From: Dunderdale, Chris <Chris.Dunderdale@lancashire.gov.uk>
Sent: 21 September 2016 17:15
To: planning
Cc: Adam Birkett
Subject: RE: Consultation on planning application 3/2016/0807 Calder Farm, Settle Road, Bolton by Bowland BB7 4NT.

The application is for the retention of eight unauthorised hard standings and creation of eight additional hard standings for caravans. Replacement of existing temporary facilities building with wooden toilet, shower facility and wash/dry room. Supplementary planting scheme with native species trees and shrubs.

Site Plan - Proposed

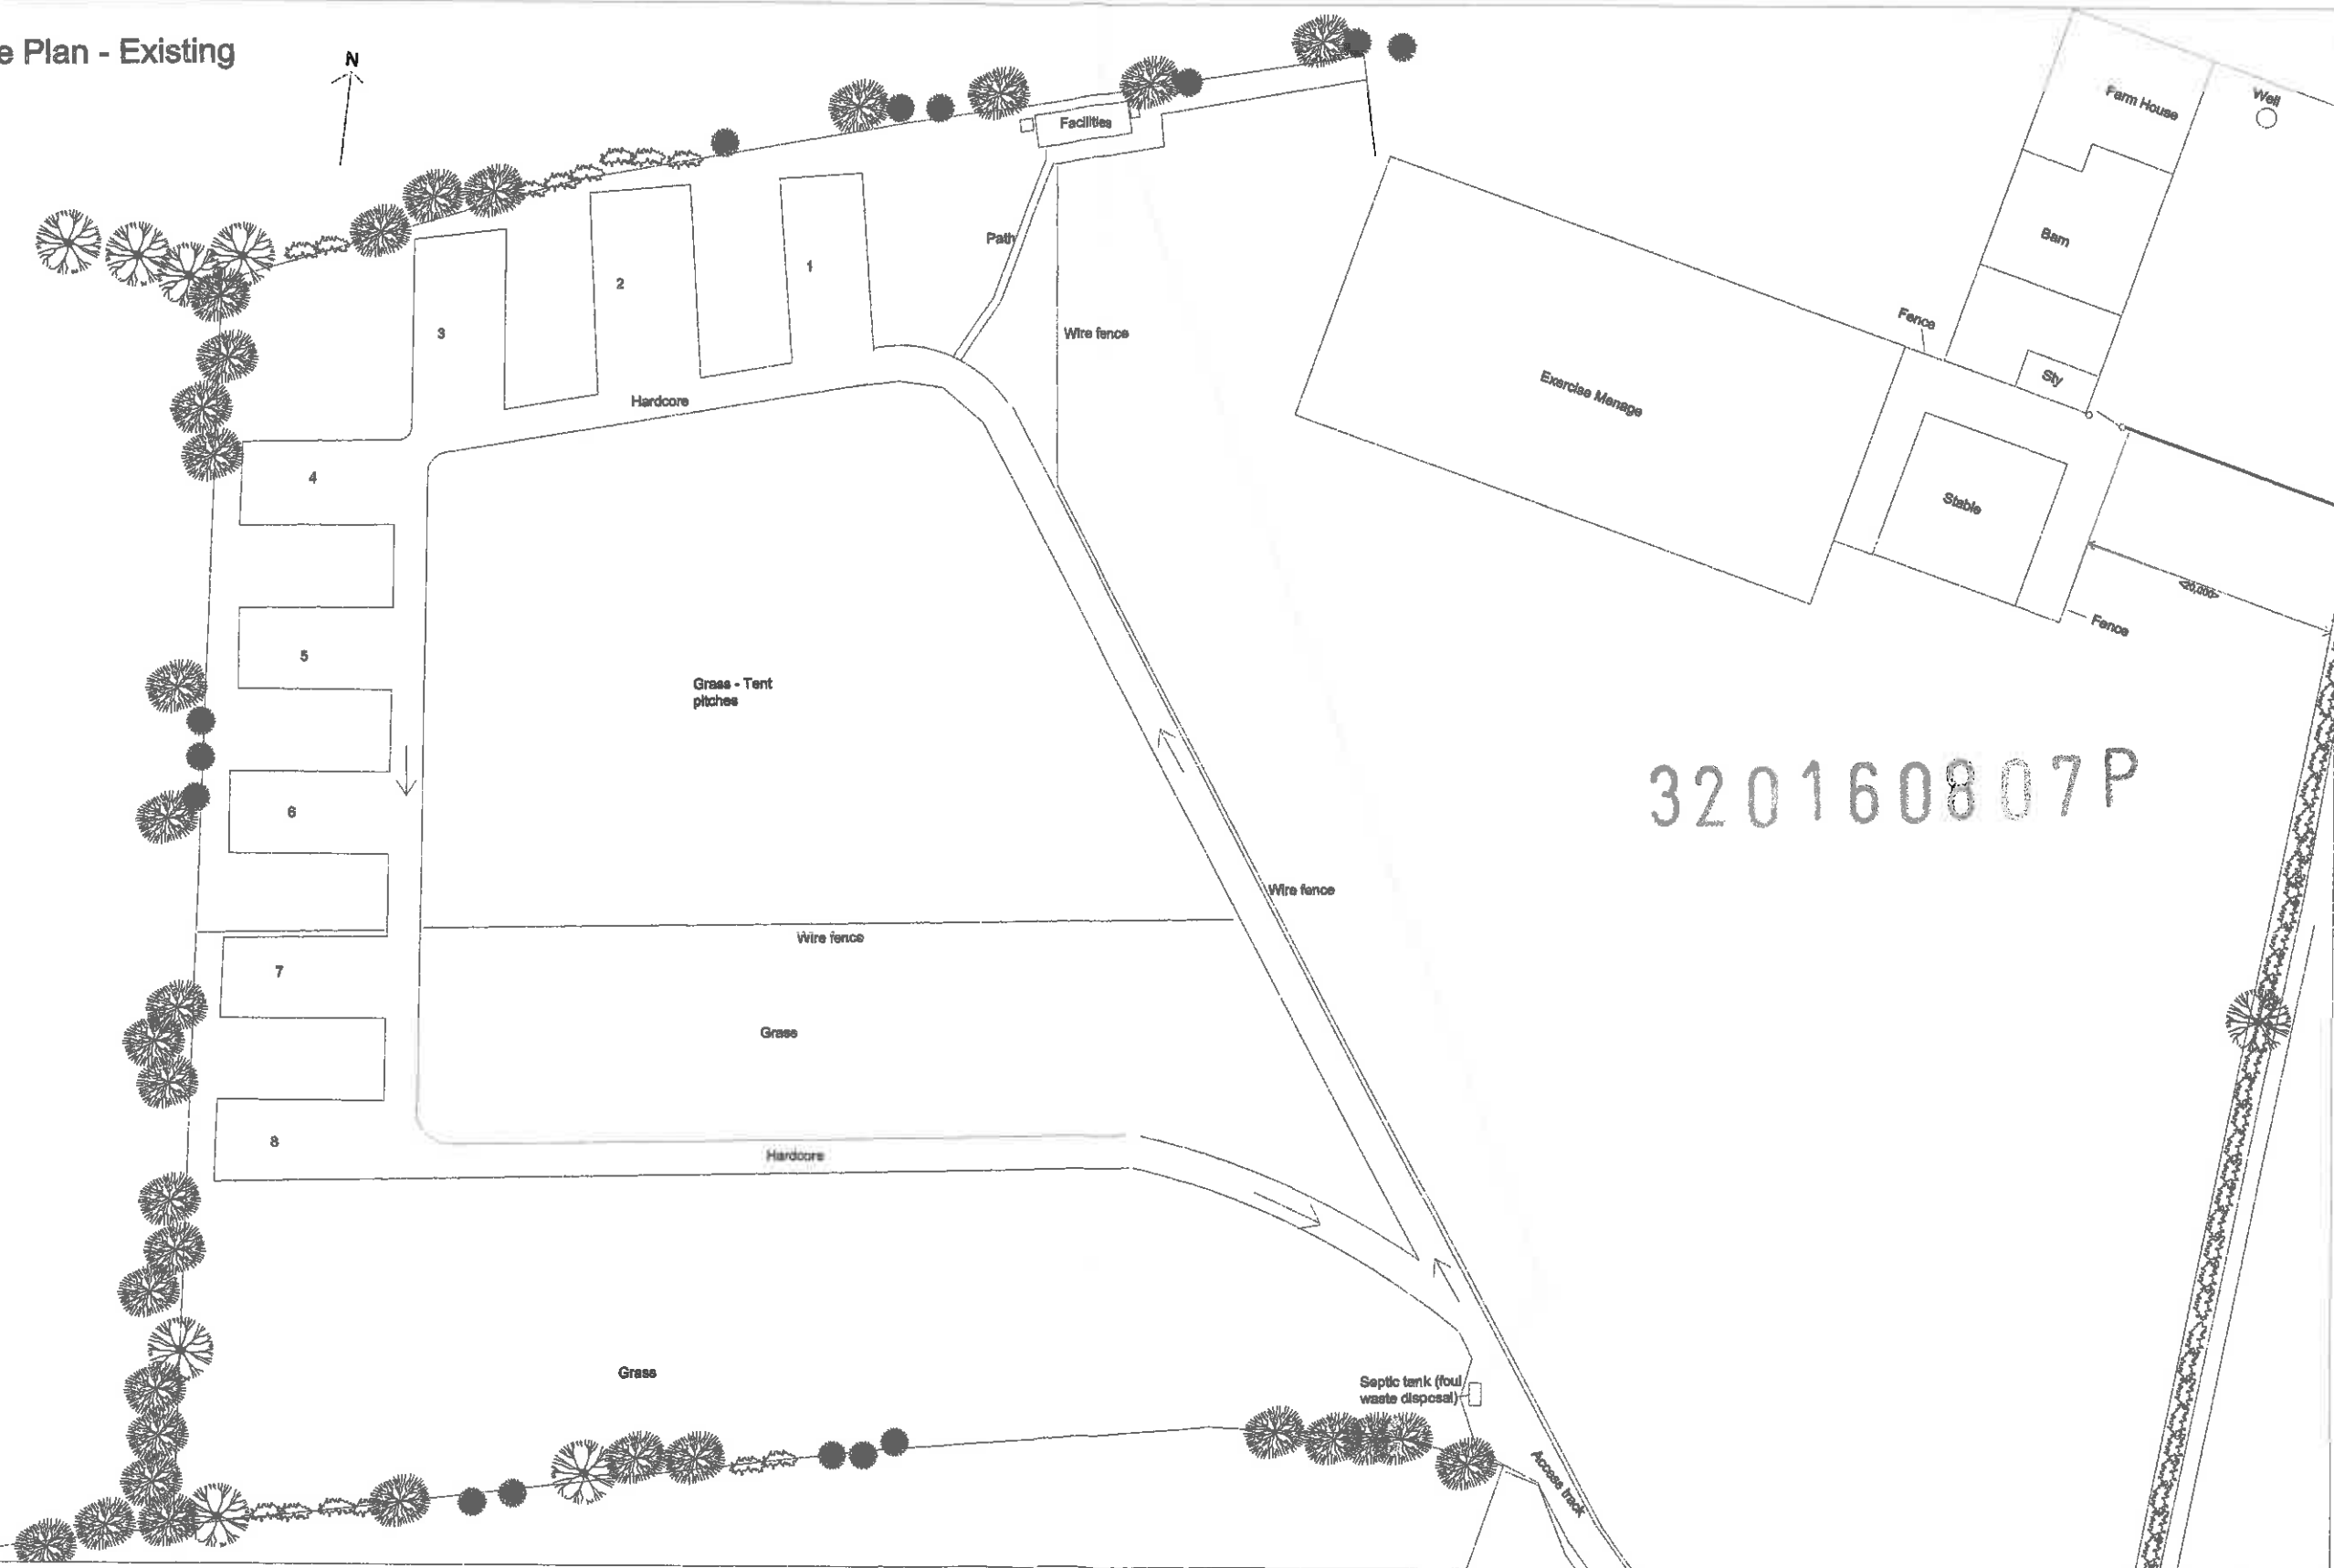
a) **Insufficient information relating to the site and drainage layout:** In the absence of sufficient information relating to the site and drainage layout, the LLFA is unable to assess the principle of surface water drainage associated with the proposed development. The LLFA would therefore, request for the applicant to provide additional information which sufficiently demonstrates how surface water will be managed on site. The applicant would be expected to provide the following information which, as a minimum, should satisfy the principles of Paragraph 103 of the NPPF and Paragraph 80 of Section 10 of the PPF:

- A plan showing the topography of the site (with contours of 1m intervals) and identification of catchment area(s)
- Details of any existing and/or proposed surface water flow routes, flood water exceedance routes, drains, sewers and watercourses

- Details of any sustainable drainage proposals
- Details of any flood risks associated with main river sources, coastal sources, surface water and ground water.

- A site investigation report, including the results for each sustainable drainage system feature of boreholes or trial pits; infiltration (permeability) testing, factual ground investigation report and geotechnical design report.

- Details of inlets, outlets and flow controls
- Long and cross section drawings of proposed drainage systems, including design levels
- Details of appropriate water quality treatments

- Details of proposed sustainable drainage system flow calculations, on-site storage requirements and a storm simulation plan for the 1 in 1 year; 1 in 2.2 year (QBar); 1 in 30 year and 1 in 100 year (+ allowance for climate change).

b) **Disposal of surface water:** The application form submitted by the applicant indicates that they intend to dispose of surface water via an existing watercourse. This appears to be contrary to planning practice guidance which establishes a hierarchy for surface water disposal. Generally, the aim should be to discharge surface run off as high up the following hierarchy of drainage options as reasonably practicable:

Should the applicant intend to dispose of surface water via an existing watercourse, then they would be expected to provide robust justification or evidence as to why preferable runoff destinations, notably into the ground (infiltration), cannot be used for this development proposal.
